Consultation Response from: KC Environmental Health (Pollution & Noise Control)

2026/92485 adj, 43, Bridle Street, Soothill, Batley, WF17 6LU

Discharge of details reserved by conditions 3 (Phase I Desk Study Report), 4 (Phase II Desk Study Report) , 5 (Remediation Strategy), 6 (Remediation Strategy), 7 (Validation Report), 8 (intrusive investigations) on previous permission 2023/93729 for erection of detached dwelling

Responding Date:
12/10/2026

5.0 Ground Model – Plan – Site Scale

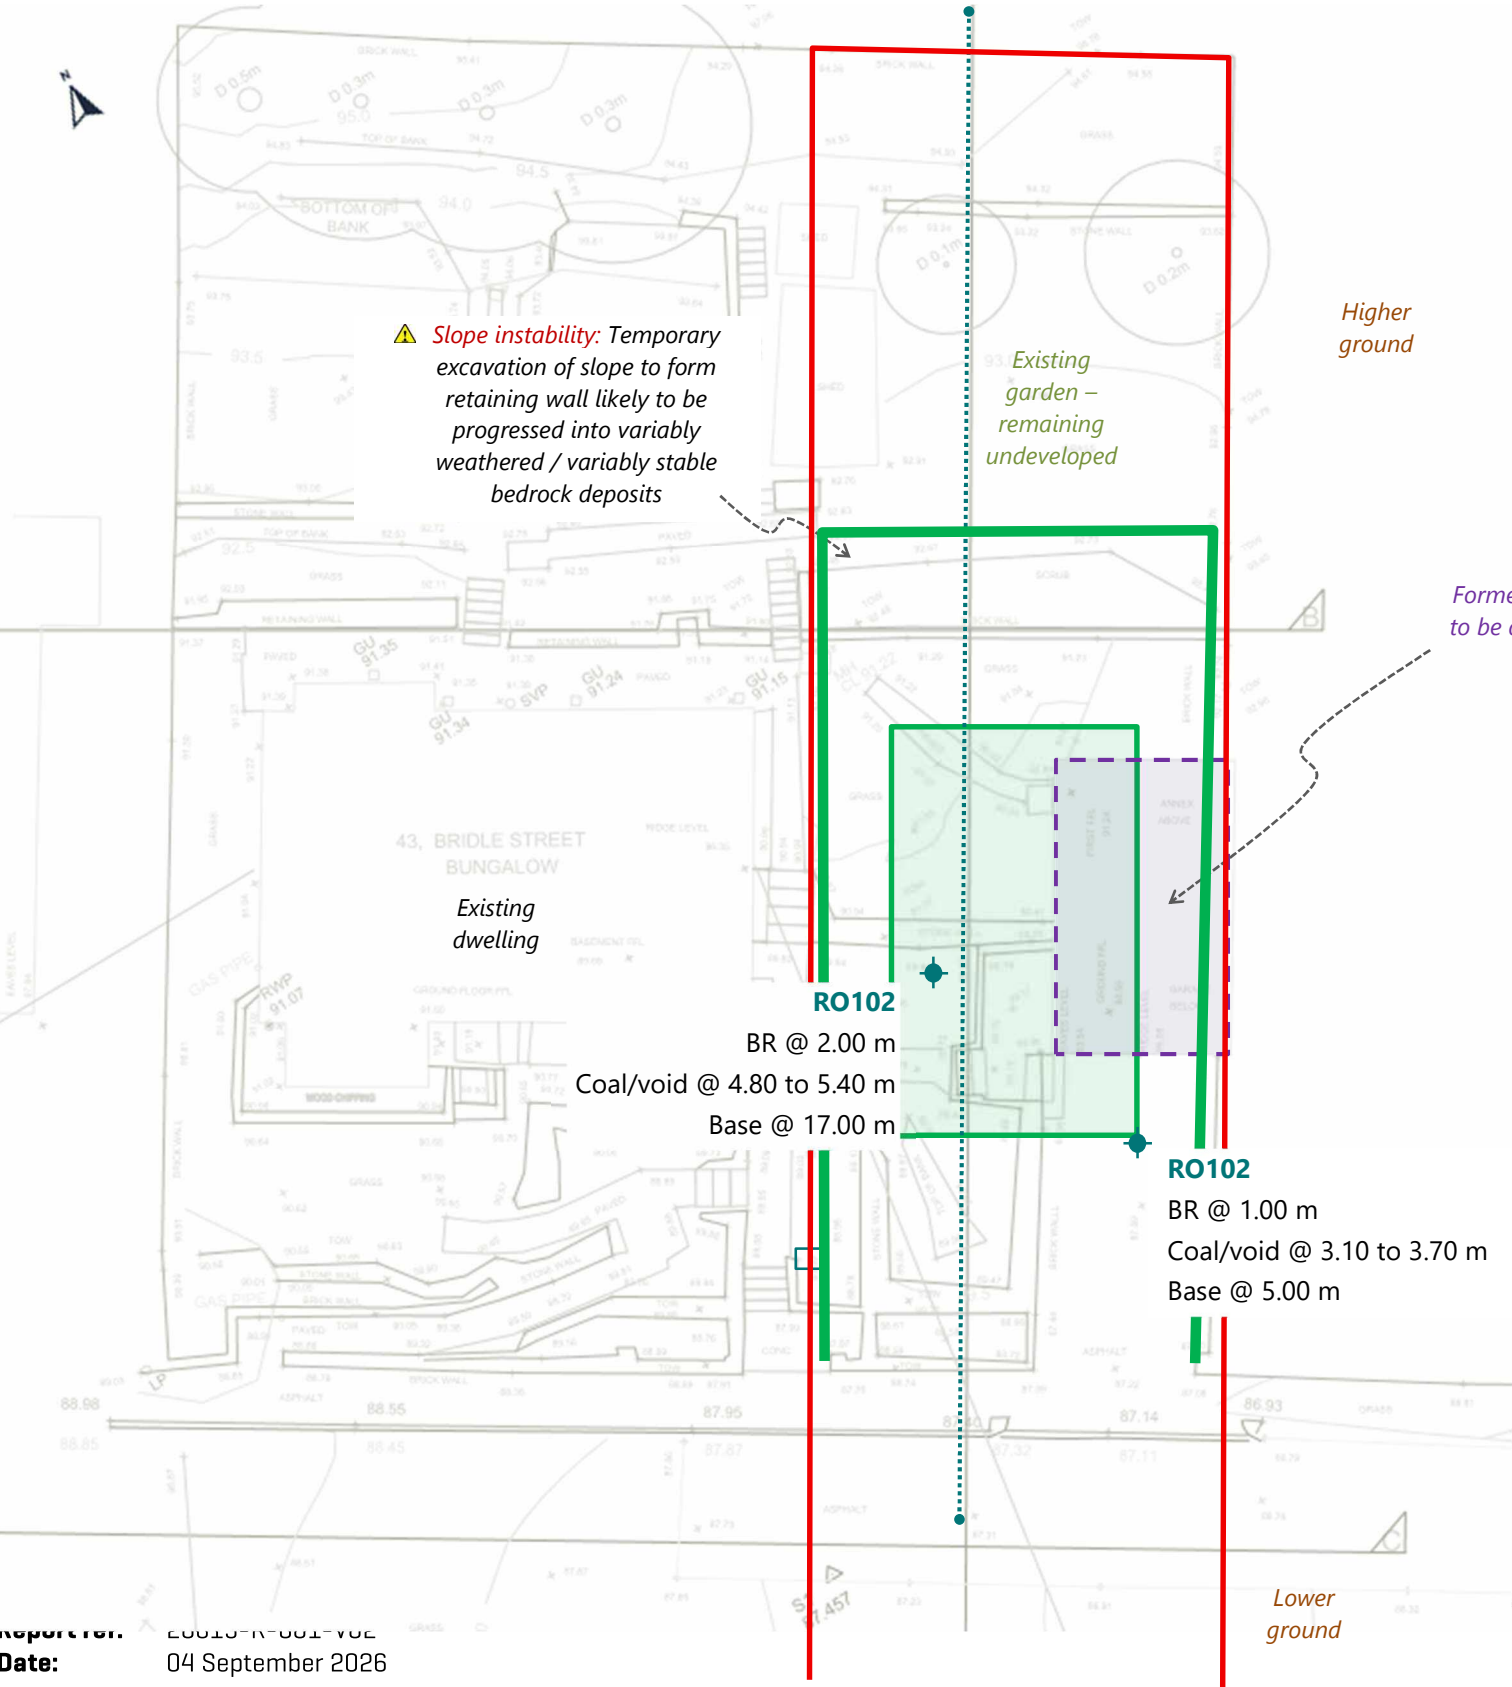
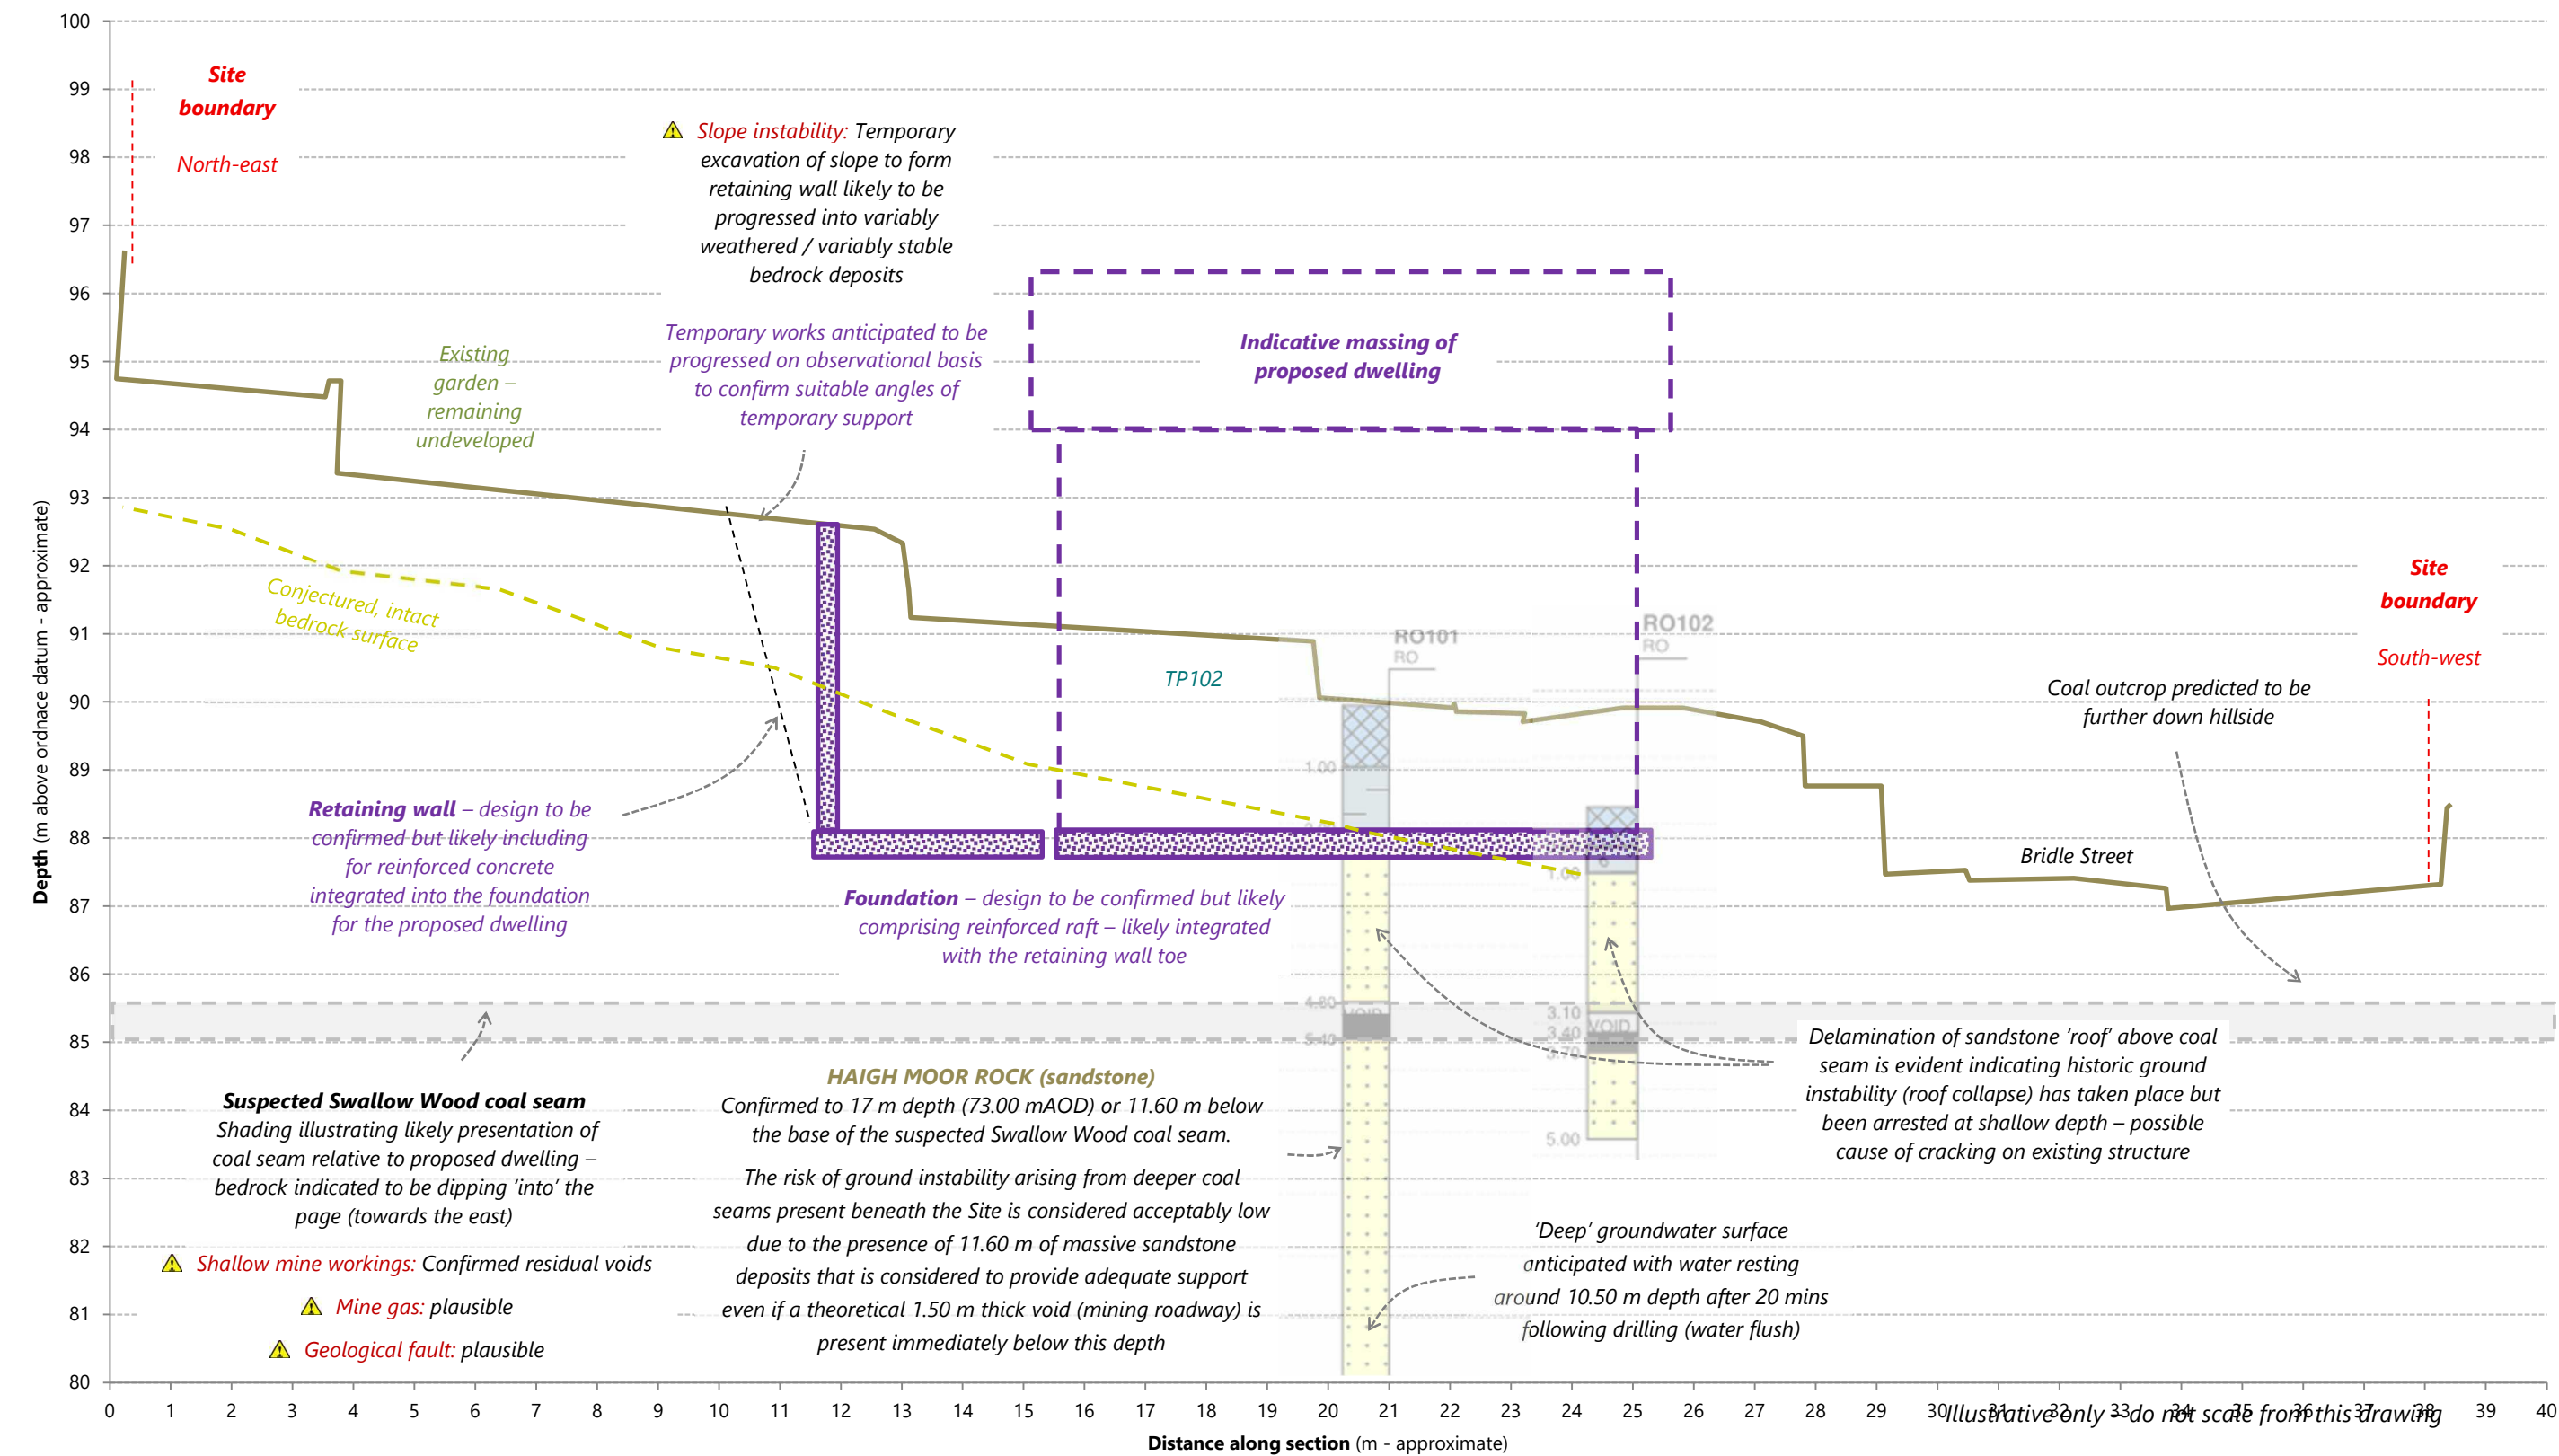
As discussed under Condition 3, the submitted report does not provide an adequate pCSM and therefore the rationale for the scope and design of the intrusive investigation cannot be adequately assessed.

It should be noted that Made Ground was encountered in both exploratory hole locations during the intrusive investigation; however, no environmental soil sampling, groundwater analysis or ground gas monitoring was undertaken.

The conclusion that no potentially harmful or polluting Made Ground is present appears to be based solely on visual observations made during the investigation. Whilst no staining, unusual odours, hydrocarbon impacts or asbestos-containing materials were identified, the absence of such indicators does not demonstrate that the Made Ground is suitable for a residential end use. Given that Made Ground was recorded to depths of up to 1.0m below ground level, and in the absence of laboratory analysis, the nature and extent of any contamination associated with the Made Ground has not been adequately characterised. Consequently, it remains uncertain whether all plausible contaminant linkages have been appropriately assessed and whether the site is suitable for its proposed use.

In the absence of an adequate pCSM and supporting risk assessment, Environmental Health is not satisfied that actual or potential contamination risks have been adequately investigated in accordance with the requirements of Condition 3 (Phase I Desk Study) and would recommend that it remains at this time.

As such, it is considered premature to comment further on Condition 4 (Phase II Site Investigation) and 5 (Remediation Strategy) until further information has been received.
